| <b>Application Ref:</b>            | 3/2015/0509 | <br>Ribble Valley<br>Borough Council<br><a href="http://www.ribblevalley.gov.uk">www.ribblevalley.gov.uk</a> |
| <b>DELEGATED ITEM FILE REPORT:</b> |             | <b>REFUSAL</b>   |

| <b>Development Description:</b> | Demolition of existing poultry sheds and construction of new detached dwelling. |
| <b>Site Address/Location:</b>   | Land adjacent to Southport House Sawley Road Sawley BB7 4LE.                    |

drawing title: PROPOSED PLANS & ELEVATIONS

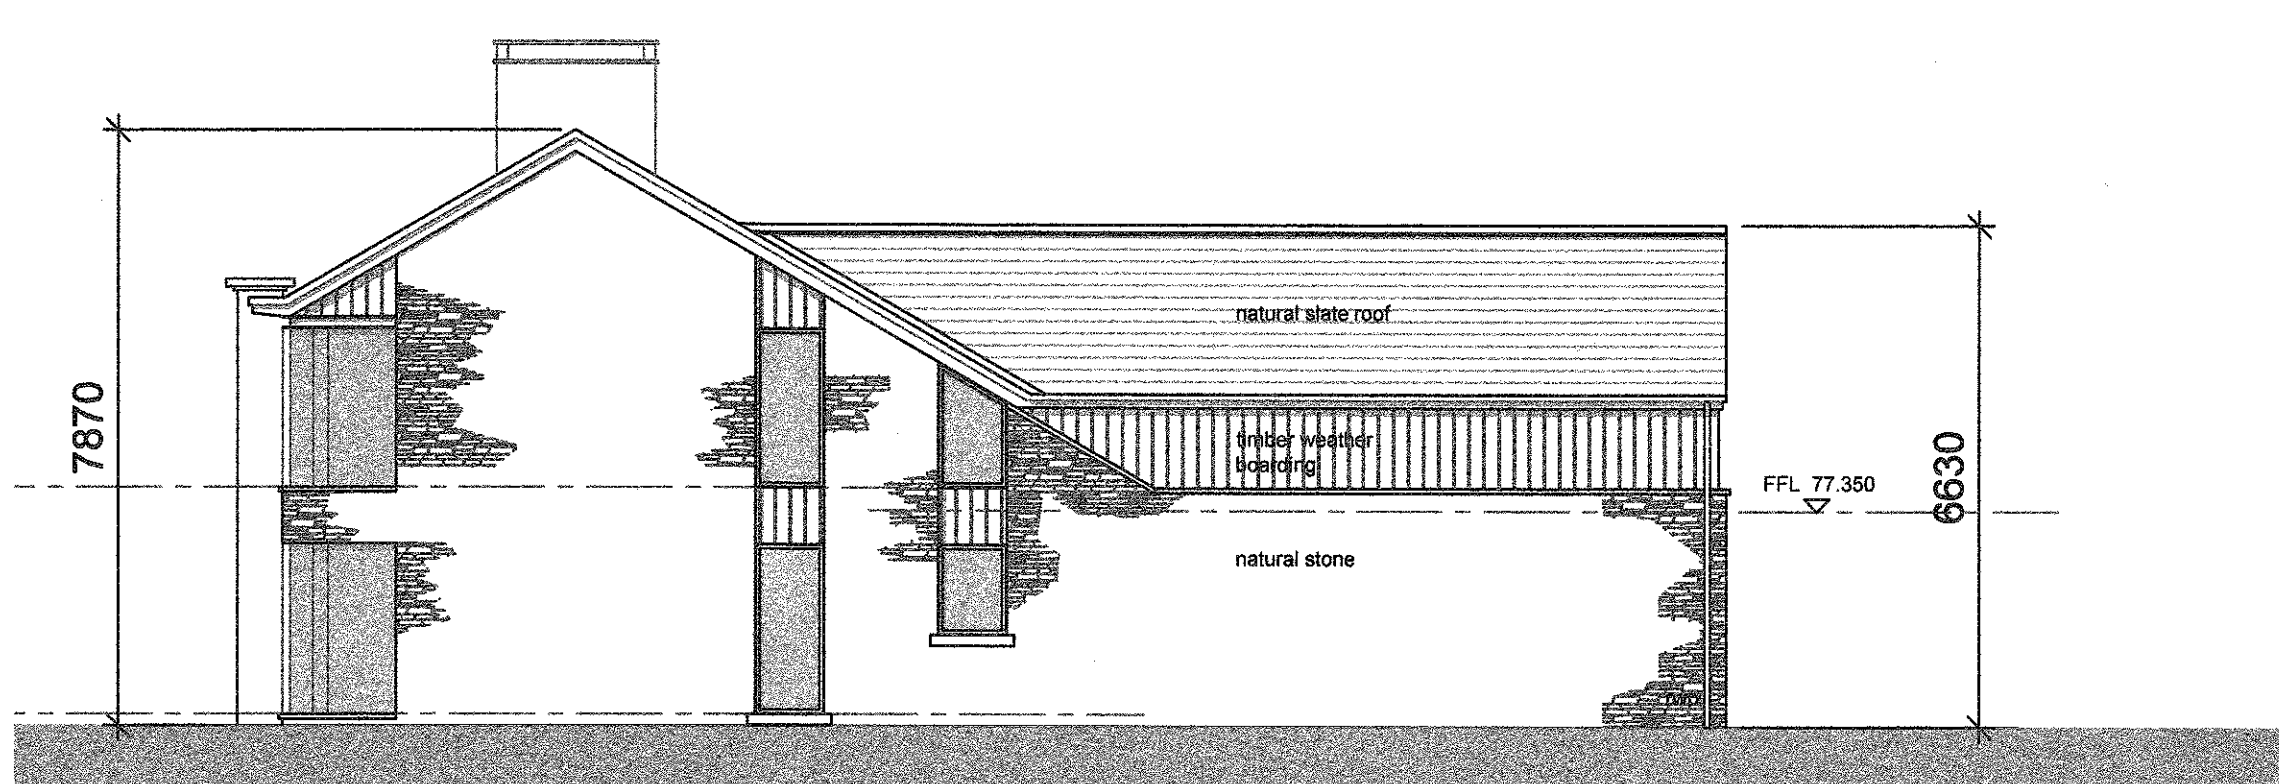
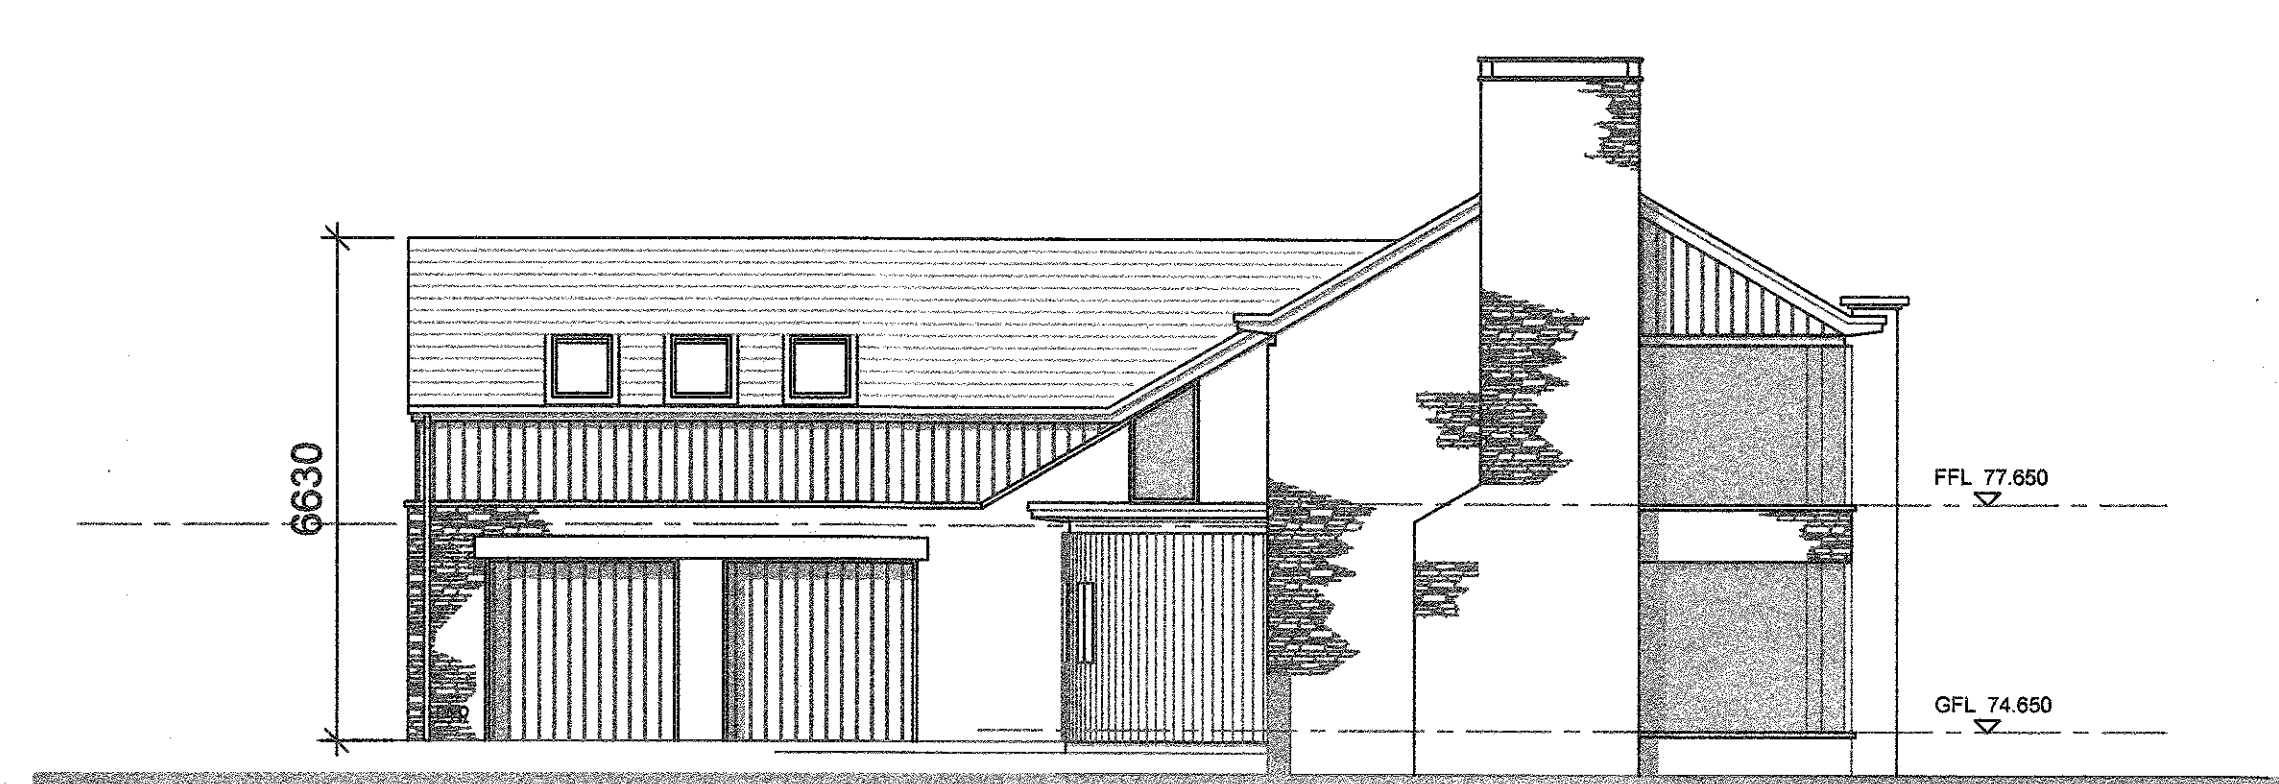
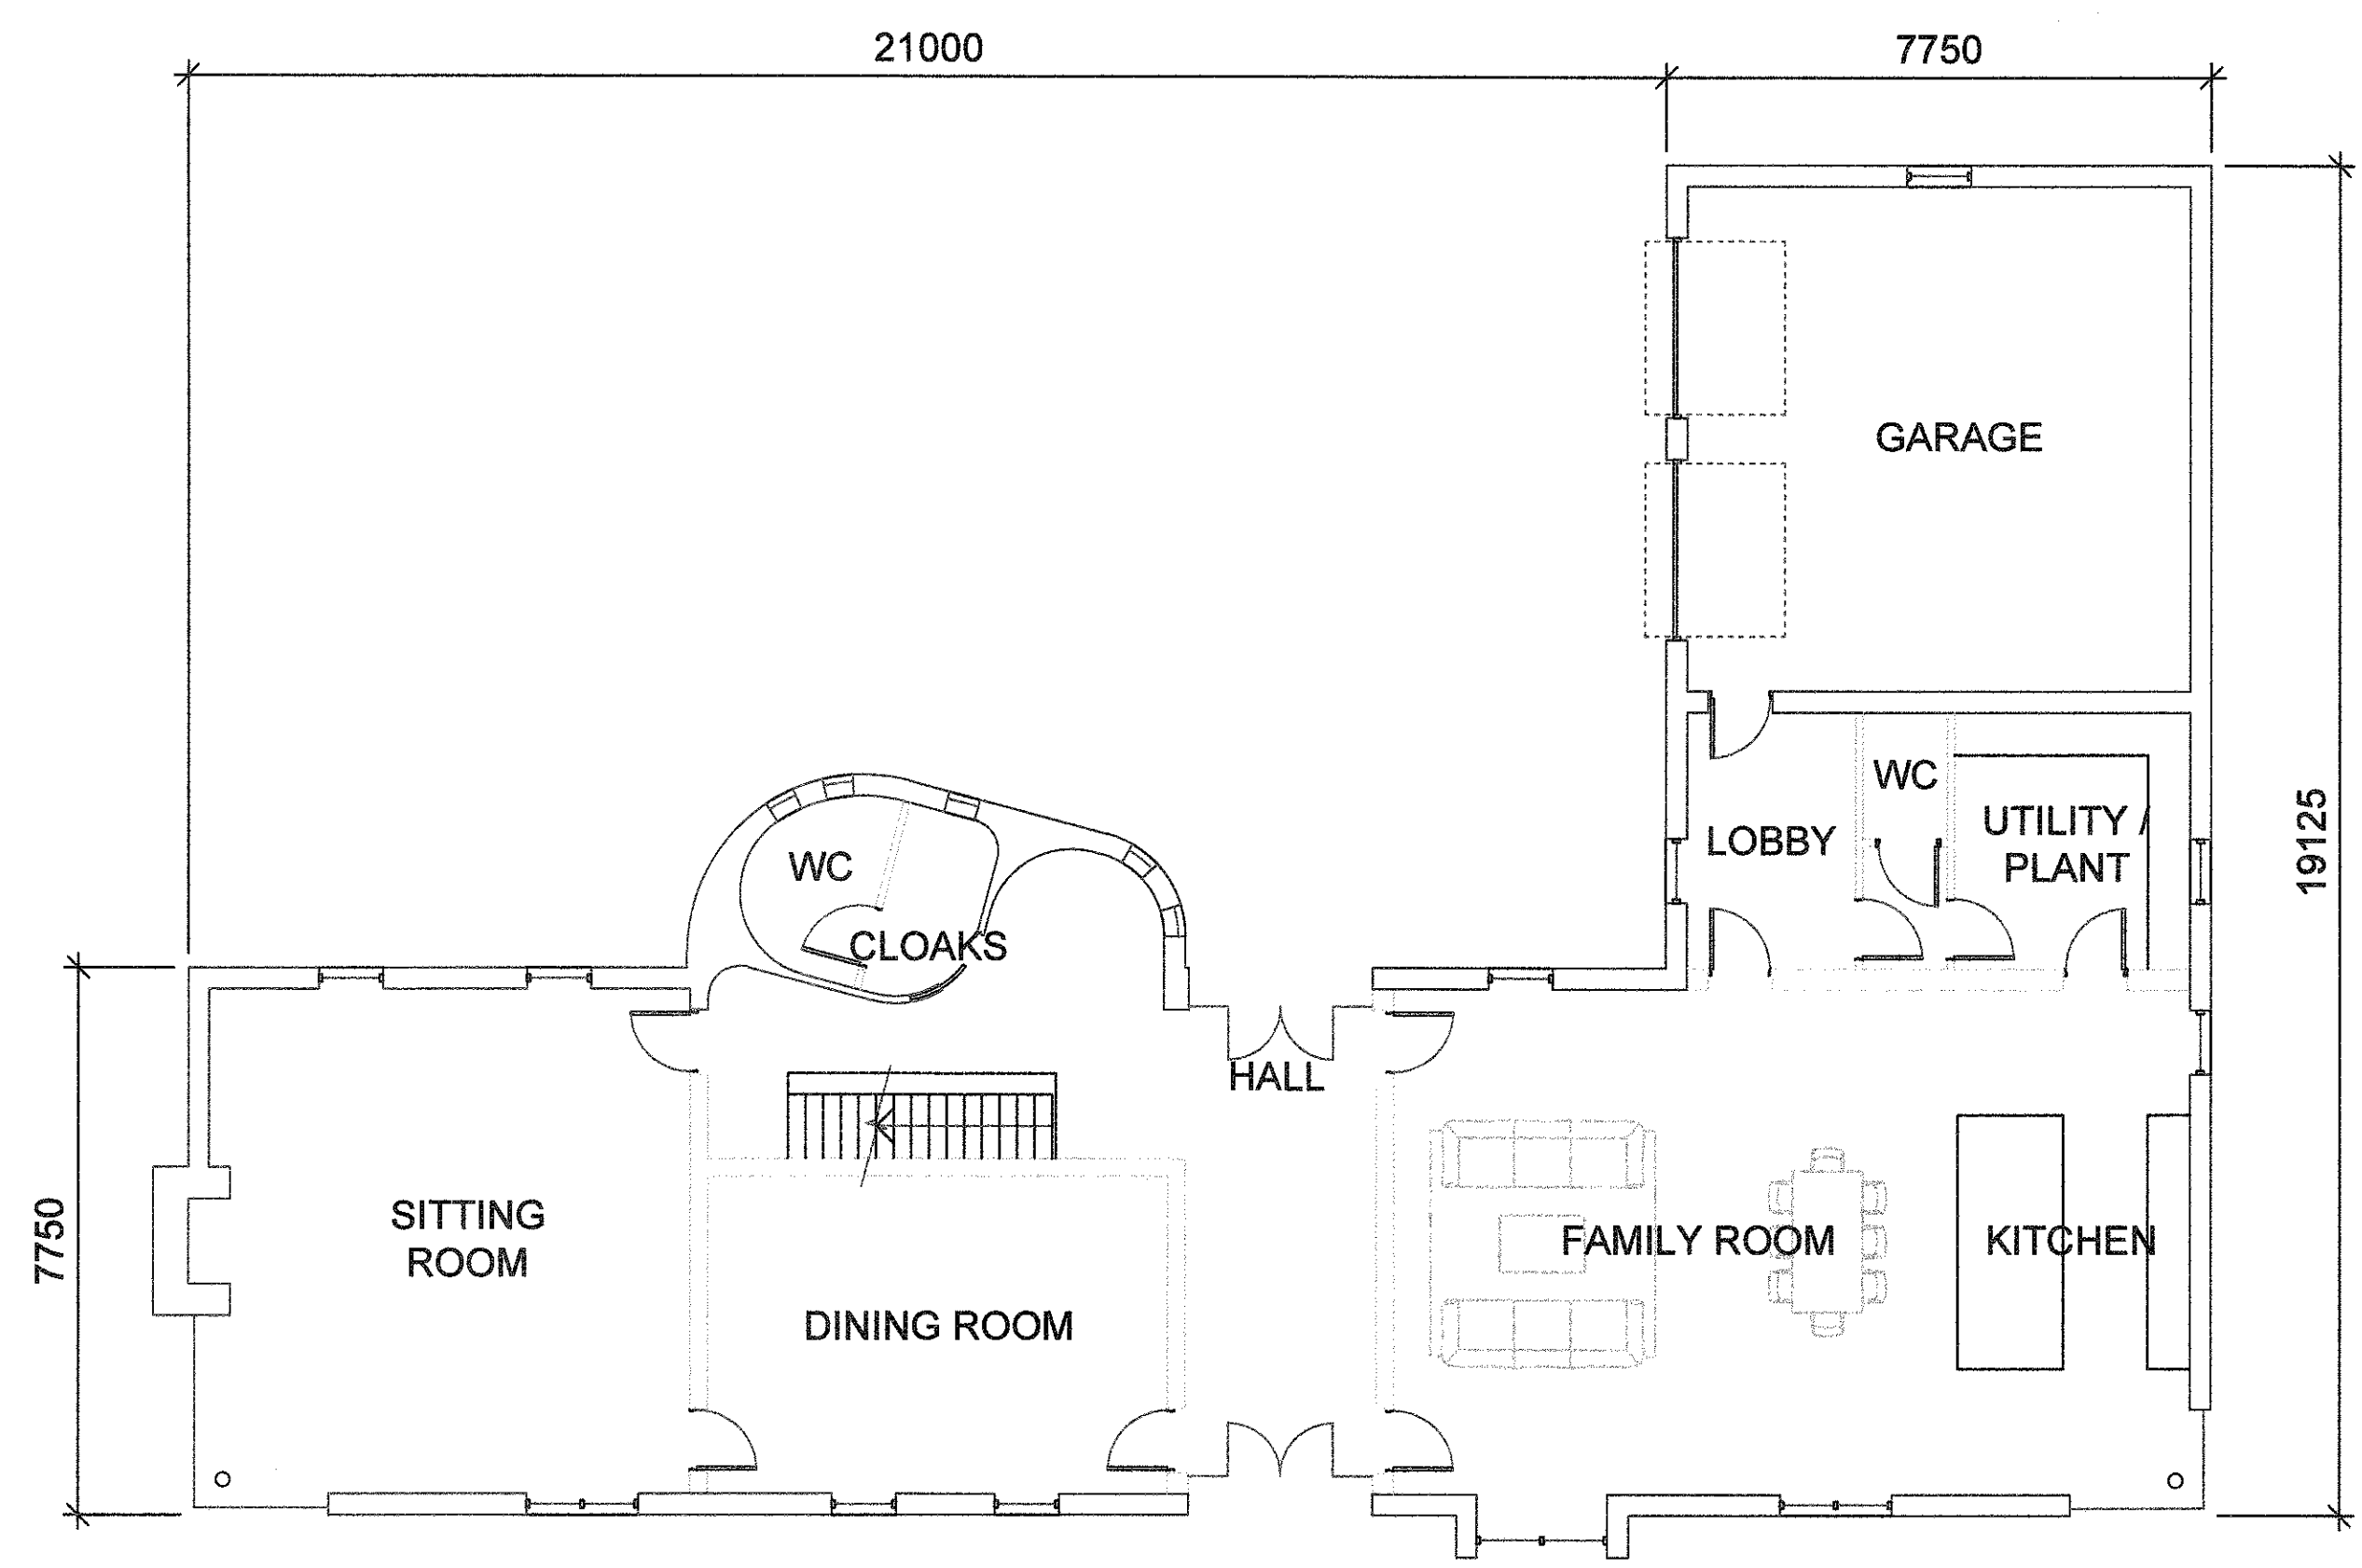
I disagree with the submitted Design and Access statement in respect to application of section 55 of the NPPF to this development. In my opinion, the design of the dwelling is not exceptional or innovative (the glass link, double garage wing and large lawned areas are particularly incongruous) and for the reasons above cannot be considered to be sensitive to the defining characteristics of the area.

| RECOMMENDATION: |   |
|-----------------|---|
| 01              | The proposal's location, size, height, materials and landscaping results in a prominent and incongruous development which undermines Sawley Conservation Area's distinct linear village morphology, its visual hierarchy of buildings ('Focal Buildings') and the significance of its open spaces surrounding Sawley Abbey. This is harmful to the character and appearance of Sawley Conservation Area, the setting of listed buildings (principally Southport House) and the cultural heritage of the Forest of Bowland Area of Outstanding Natural Beauty. This is contrary to Key Statement EN5 and Policies DMG1, DME4 and DMG2 of the Ribble Valley Core Strategy and the National Planning Policy Framework Paragraph 17 (conserve heritage assets in a manner appropriate to their significance), Paragraph 60 (reinforce local distinctiveness), Paragraph 115 (conserve cultural heritage), Paragraph 131 (development sustaining and enhancing the significance of heritage assets and positively contributing to local character and distinctiveness) and Paragraph 132 (great weight to conservation). |
